**KIRKLEES METROPOLITAN COUNCIL  
INVESTMENT & REGENERATION SERVICE**

Reference No:	<b>2024/70/93328/W</b>
Site Address:	Former Royd Edge Dyeworks, Holmfirth Road, Holmfirth, HD9 4BY
Description:	Variation of Condition 1 (plans and specifications) of previous permission 2021/92788 for variation of condition 7 (plans) of previous Reserved Matters approval 2009/92557 for residential development for 30 dwellings with associated parking pursuant to outline permission 2007/92595
Recommending Officer:	William Simcock

## Officer Report

**2024/93328 - Former Royd Edge Dyeworks, Holmfirth Road, Meltham, Holmfirth, HD9 4BY**

Drawing: **HOUSE TYPE E - 2 BEDROOM.**

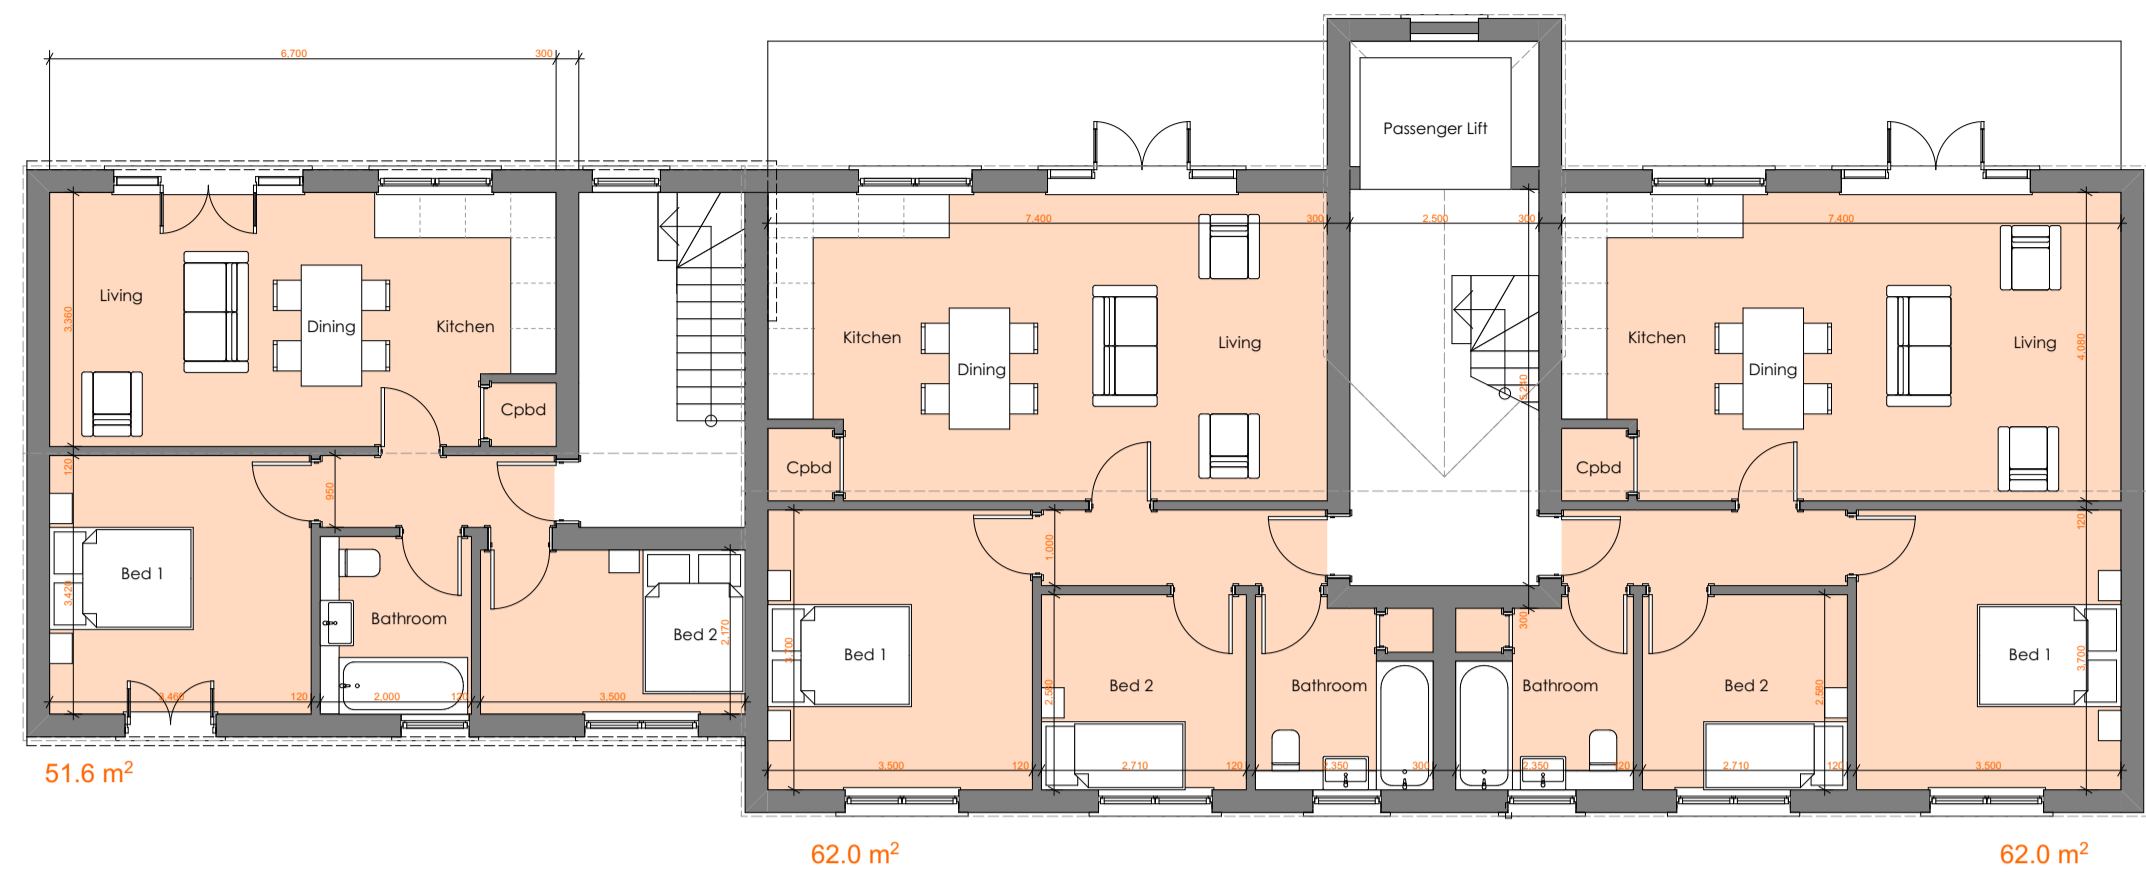
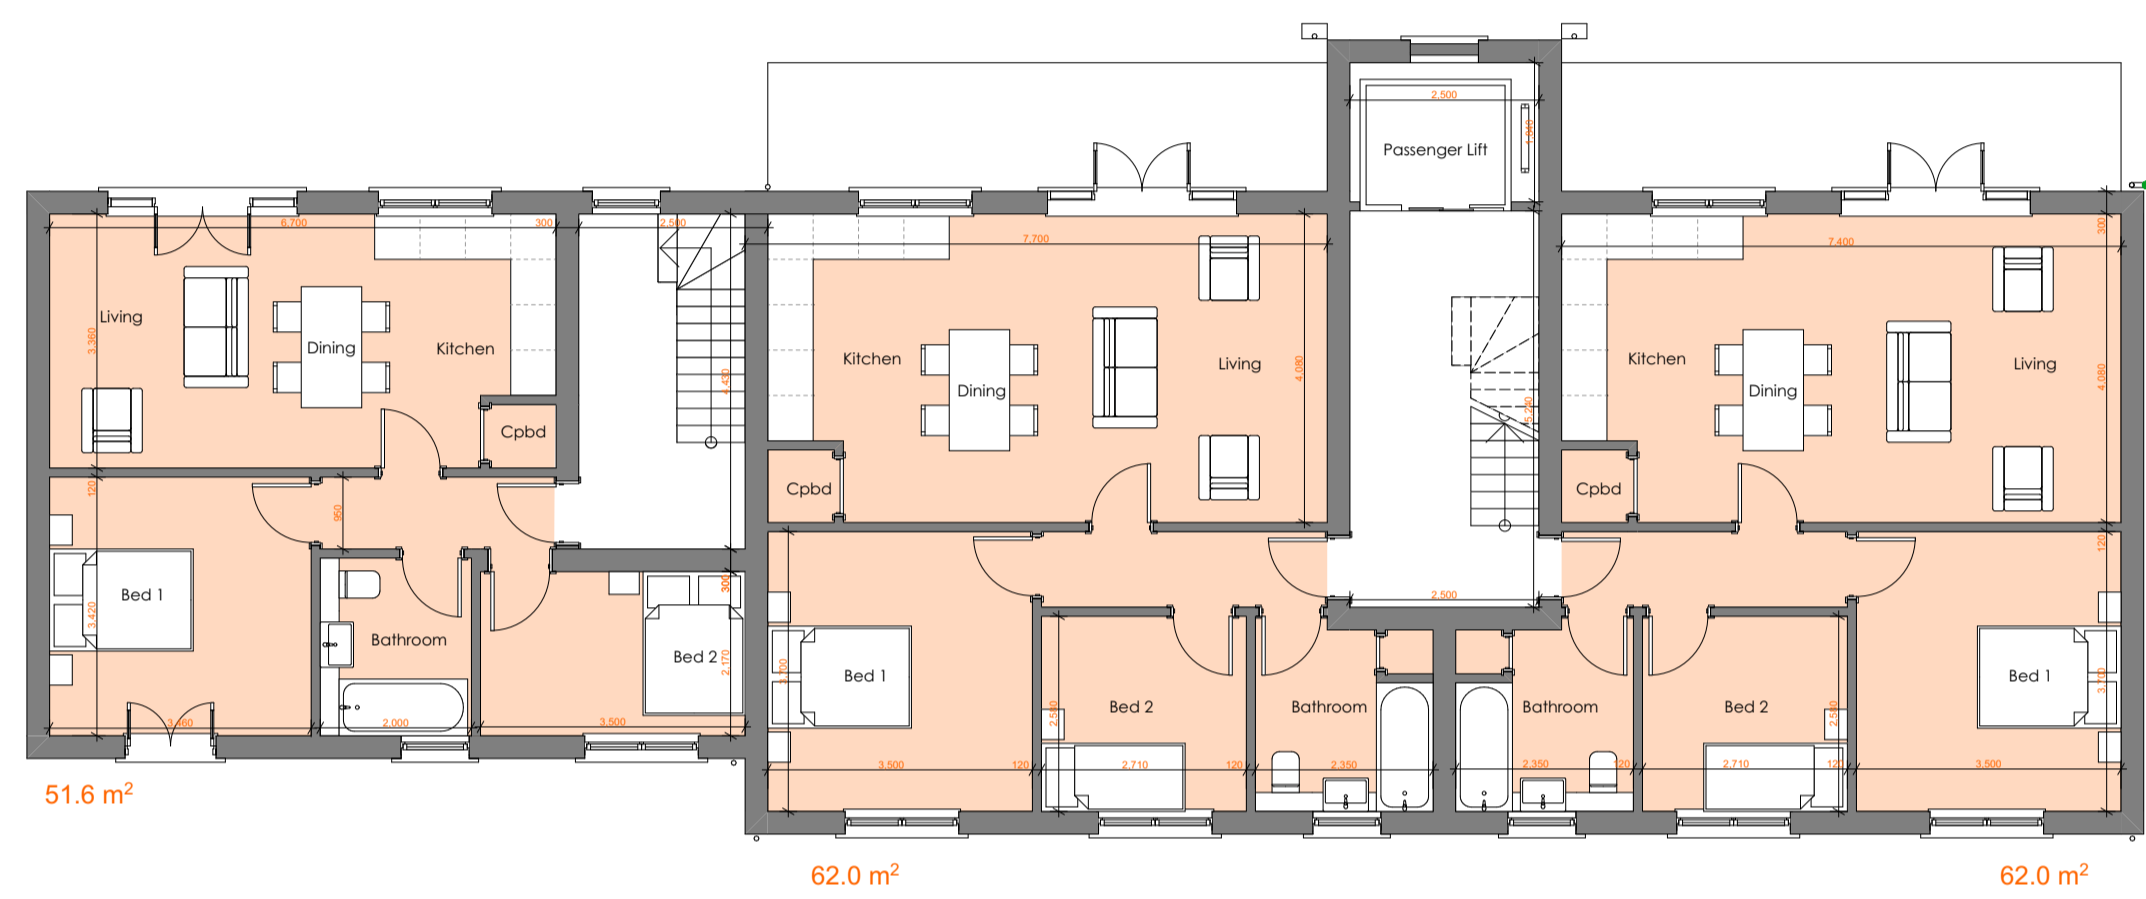
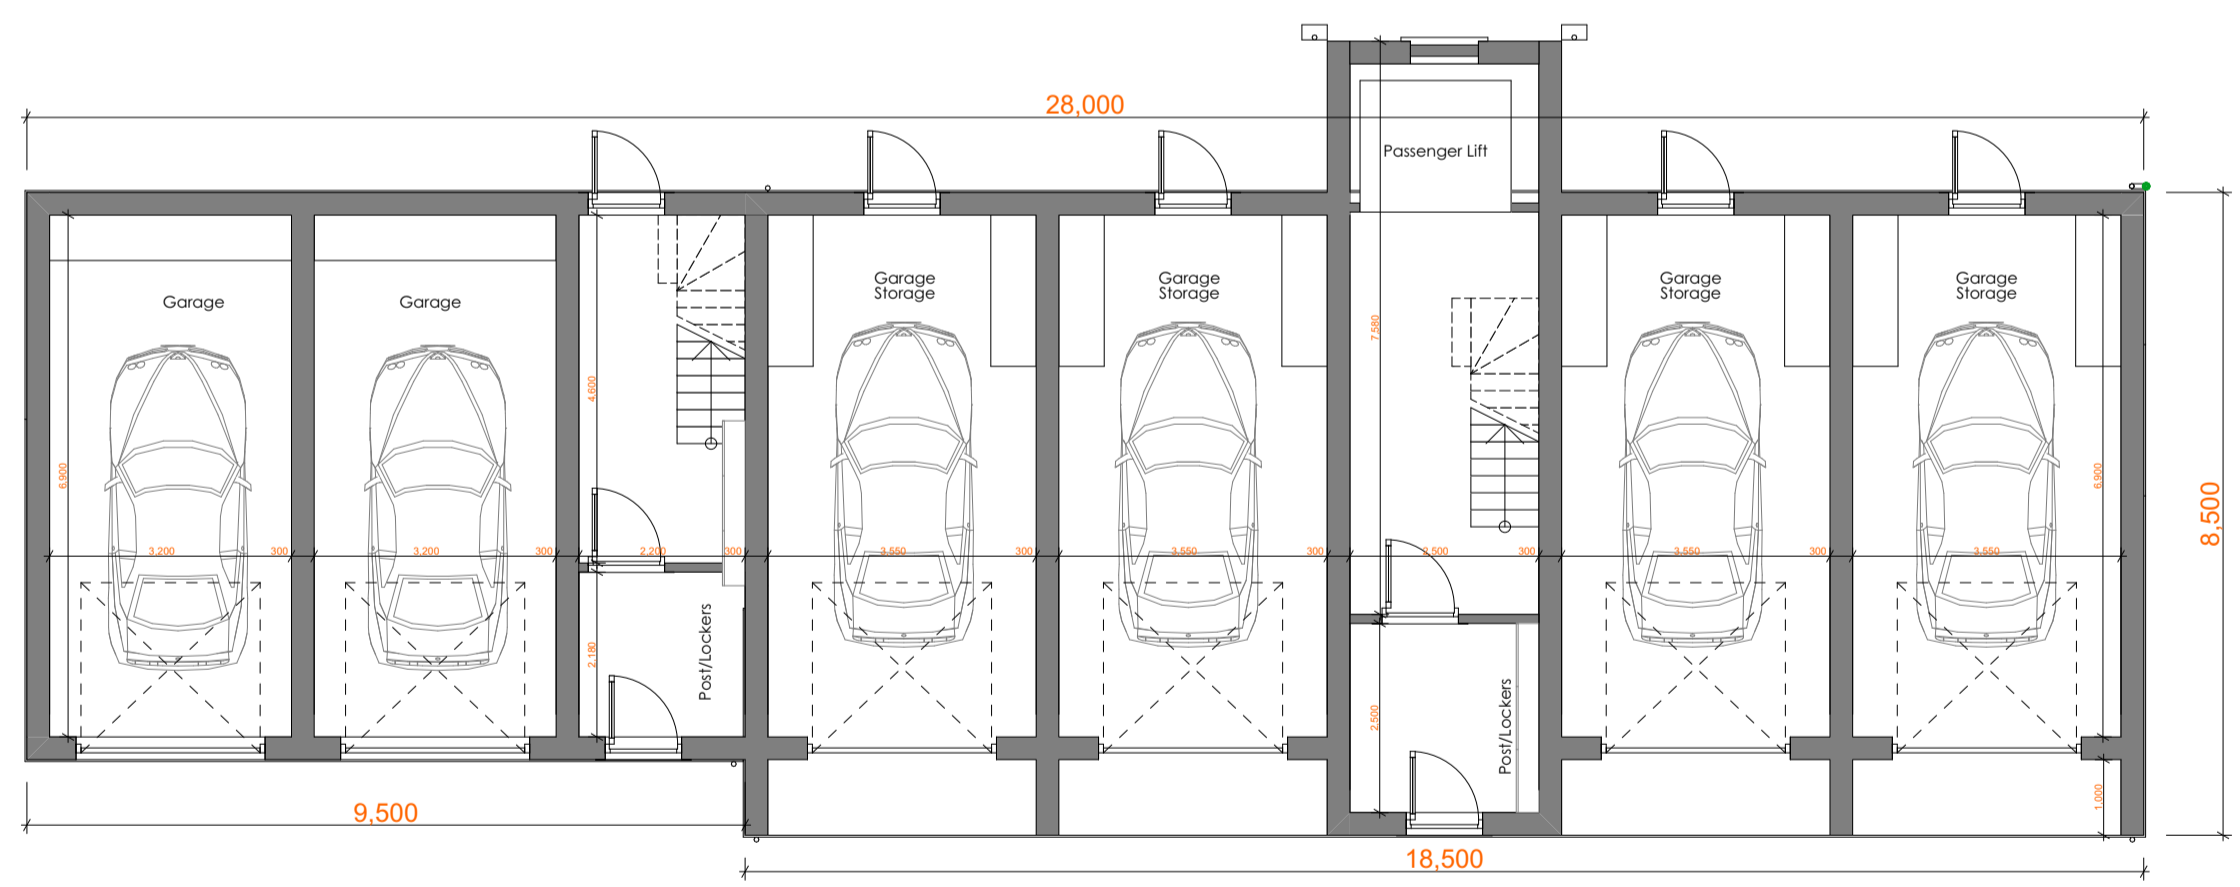
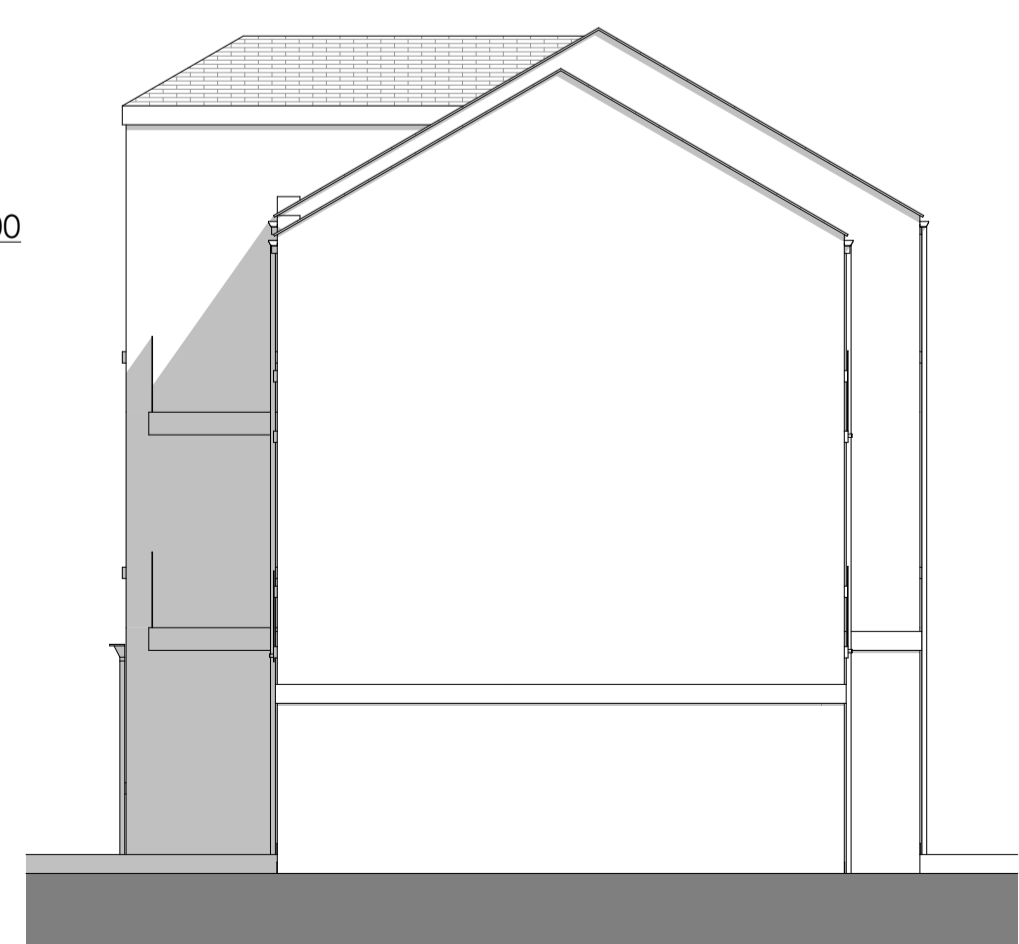
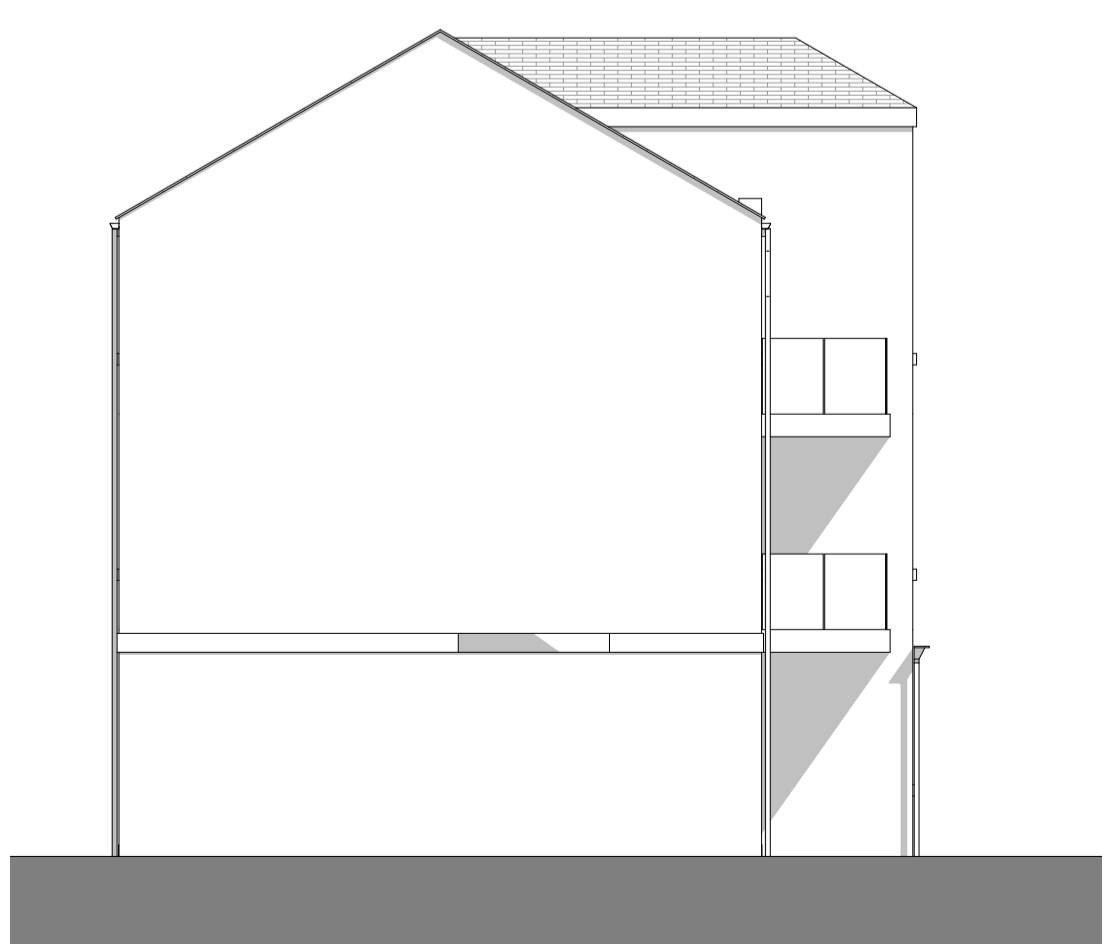
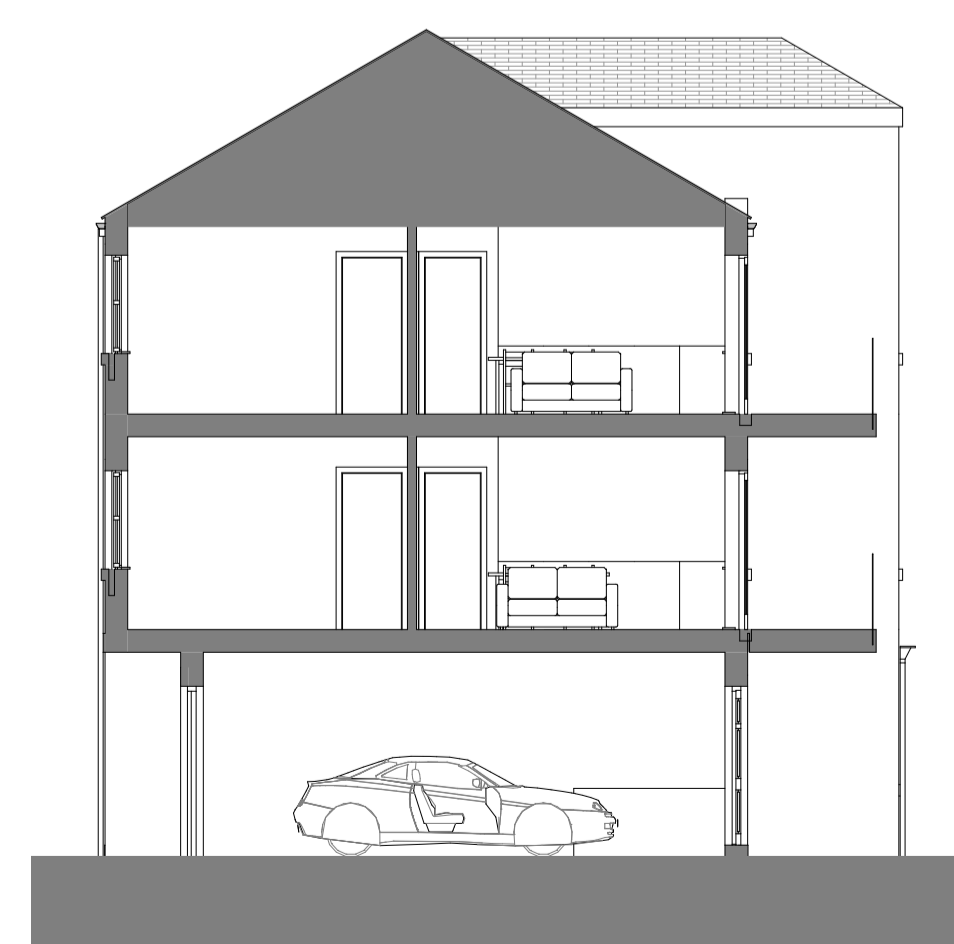
- 1) Alterations to the approved house type on plots 21 and 22. Plot 21 would change from the approved house type F1 (four bedroom) to house type F (three bedroom), becoming a detached unit. It would lose its attached garage, and its parking would be located to the front of the plot. Plot 22 would remain as house type F1 but become a detached unit, decoupled from plot 21.
- 2) The houses would still be built using the approved materials schedule. However, the developer wishes to amend the design of the apartment

block - plots 9-14 - by removing the decorative chimneys on gable ends.

The loss of the external chimney stacks to plots 9-14 represents only a minor simplification to their design. It is on balance considered an improvement since they would better reflect local vernacular domestic architecture.

Client:					
BROOK GROUP HOLDINGS.					
Project:					
ROYD EDGE DYEWORCS, MELTHAM,					
Drawing:					
PROPOSED SUB-STATION.					
Project No:	Drawing No:	Scale:	Date:	Drawn by:	Checked by:
1629	09_01B	1:50	Feb '25	DW/Others	—

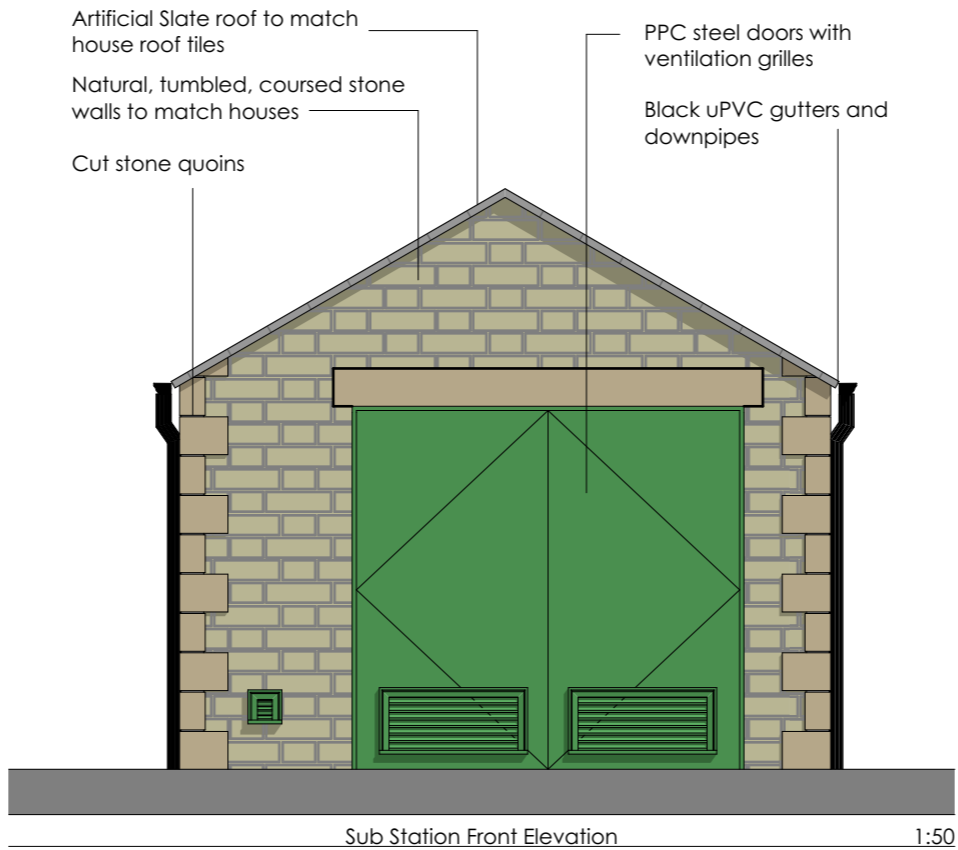
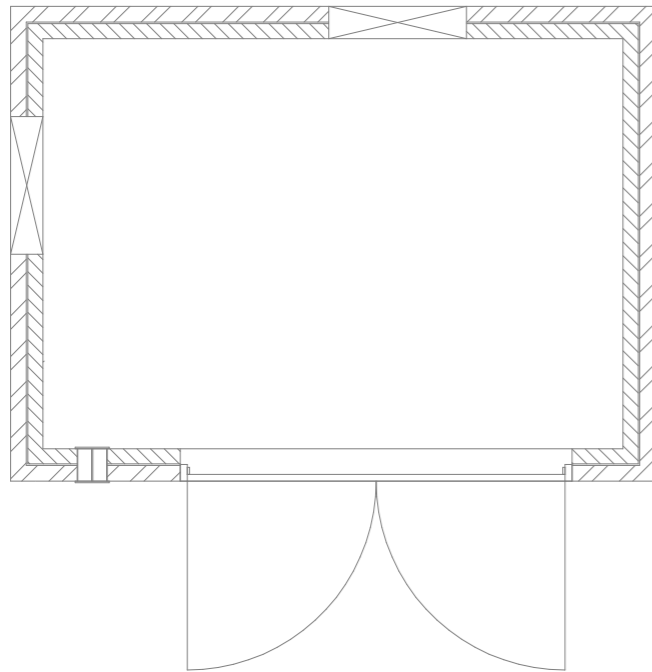
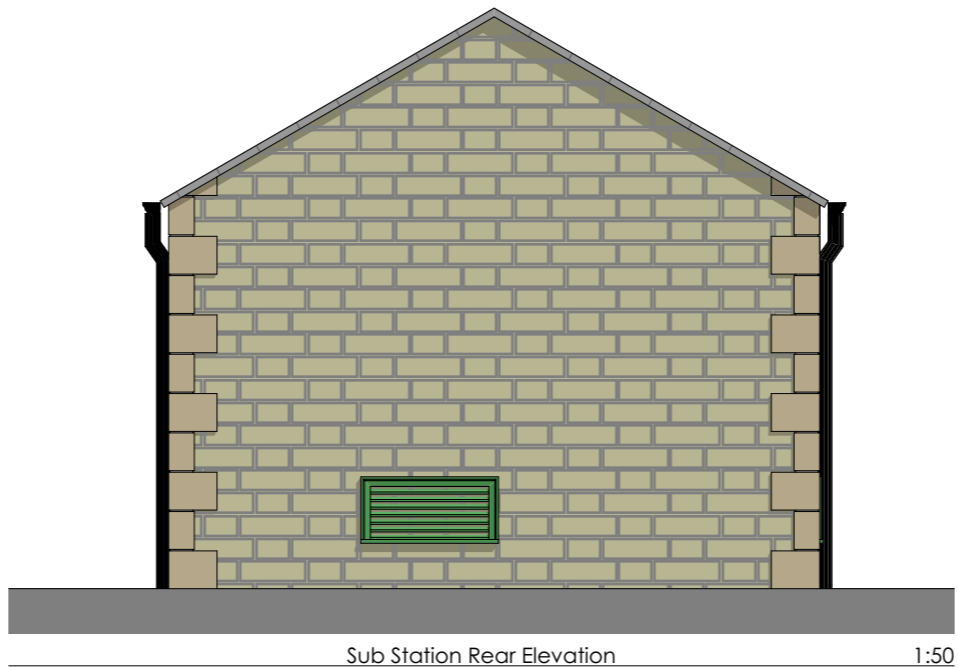
- 3) A substation is to be added to the site, at the south-western corner of the estate road adjacent to Plot 22 and the visitor parking spaces. This is to be externally faced in stone, with an artificial stone slate roof.

Substation redesign requested by case officer.

The substation will be 2.5m high to the eaves and with a double pitched roof at 30 degrees. It would be built of tumbled coursed stone and artificial stone slate. It is considered whilst it does not enhance the development, in terms of scale, design, facing materials and roof style it would harmonise with the rest of the development and is therefore an acceptable, and in this case, necessary addition.

14-Feb-2025: Amended substation plans received.
